# CITY OF ALBUQUERQUE

February 18, 2022

**RE: 14508 Sierra Ct. NE**  
**14508 Sierra Ct. NE**  
**Grading and Drainage Plan**  
**Engineer's Stamp Date: 02/01/2022 (check this)**  
**Hydrology File: L23D037**

Based upon the information provided in your submittal received 01/31/2022, the Grading & Drainage Plan is **not** approved for Building Permit. The following comments need to be addressed for approval of the above referenced project:

Drainage Plan

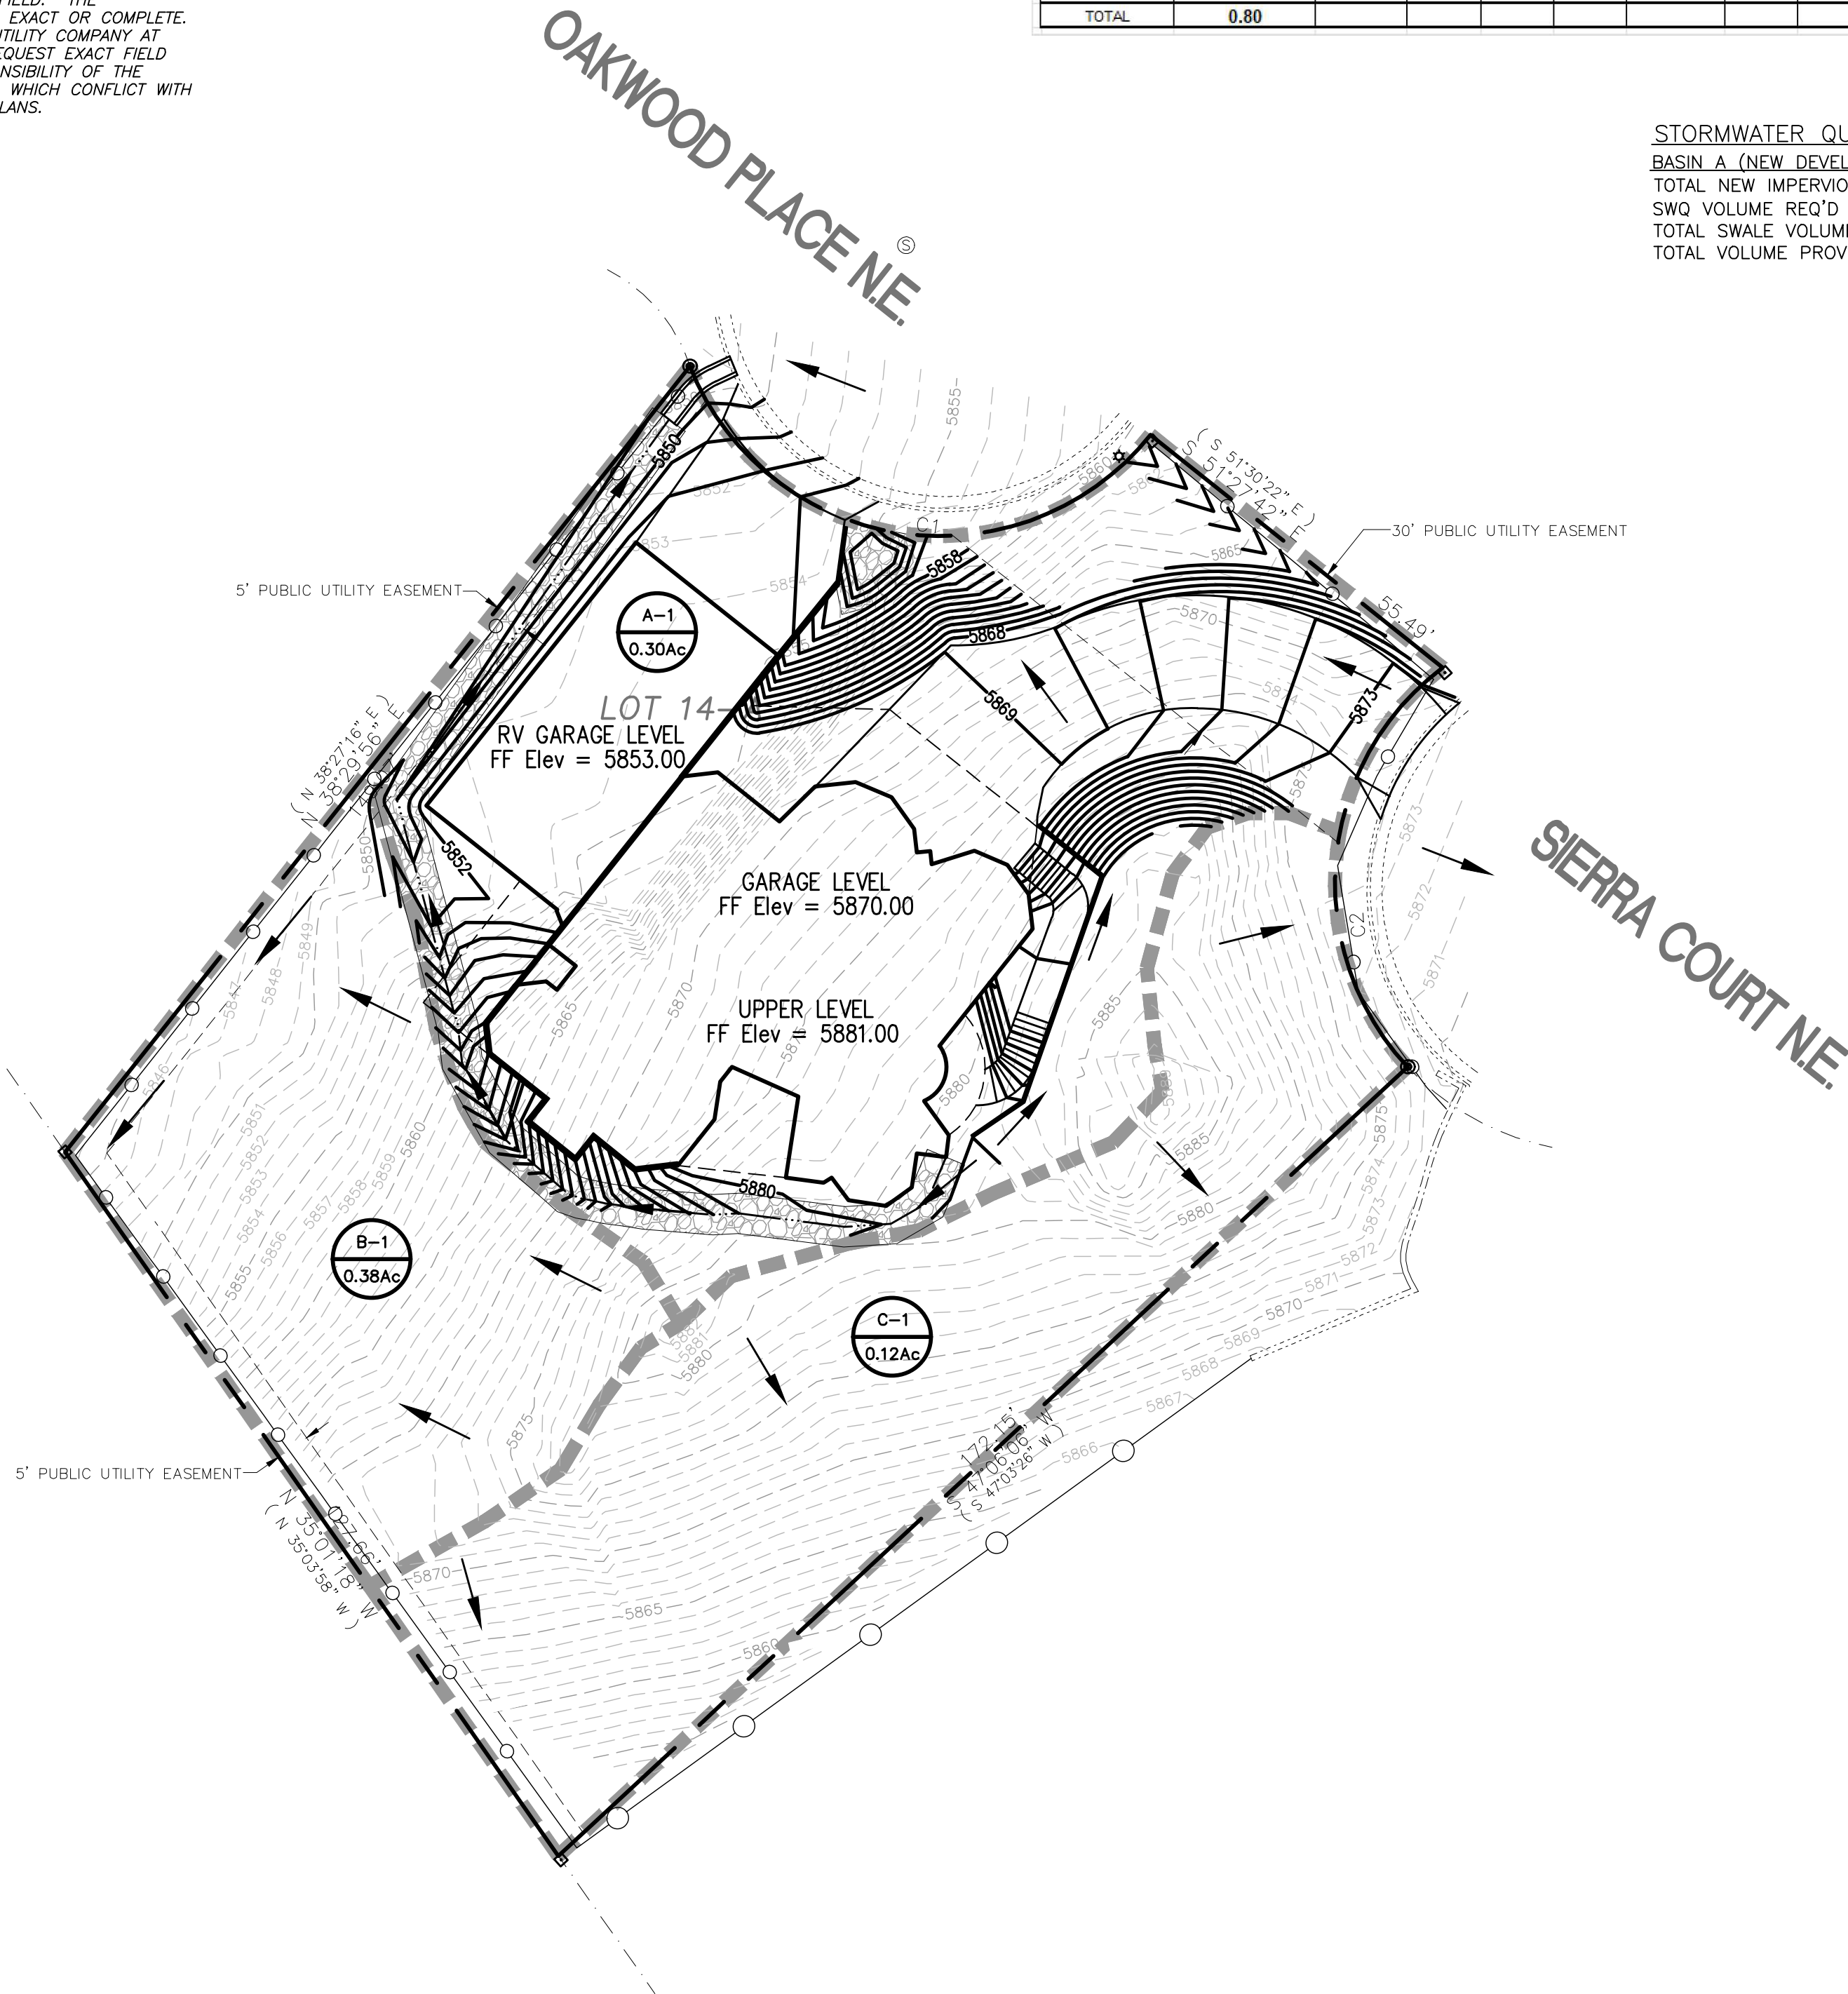
3. If there is drainage crossing the lots, a cross lot drainage easement will be required (platting?)
4. Discussion with Shahab, he mentioned it seems unlikely that basin C will be undisturbed. If any disturbance to that area, you will need to provide a pond.

- a. It would benefit the project to simply place another pond to avoid having to not touch that area. Simply driving over, it with backhoe etc... could cause enough disturbance when we go out there to seem like it is disturbed and may result in denying a CO.

5. Remove the aerial photo in the background. It clutters up the linework/design.
6. Provide a detail of the overflow and how it will discharge into the proposed swale to the roadway.

- a. This needs to be clearly shown with a cross section.
7. Please note that the approved G & D must be followed and not doing so will result in the site not receiving a CO.

Grading Plan

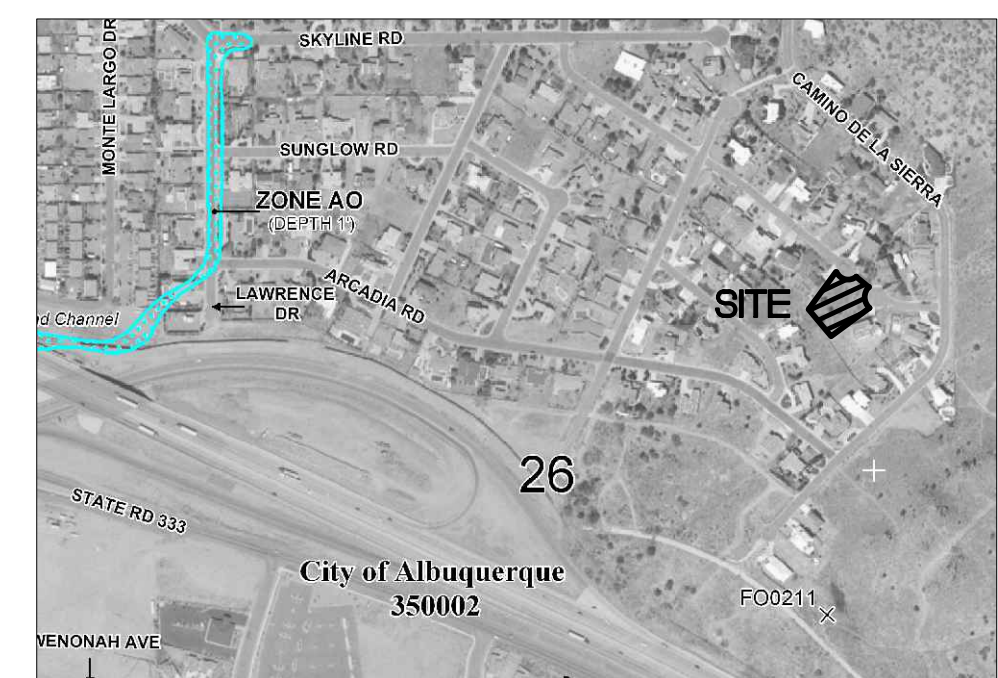
1. Review the grade at the back of the home. It appears a stem wall will be needed there as well as there is a 10 ft grade difference. Please ensure there is a detail for these stem walls appropriately.

- a. Review any other grading issues where a retaining/stem wall may be needed.
2. Prior to approving this, we will need written approval and allowance for the work being completed on adjacent property.
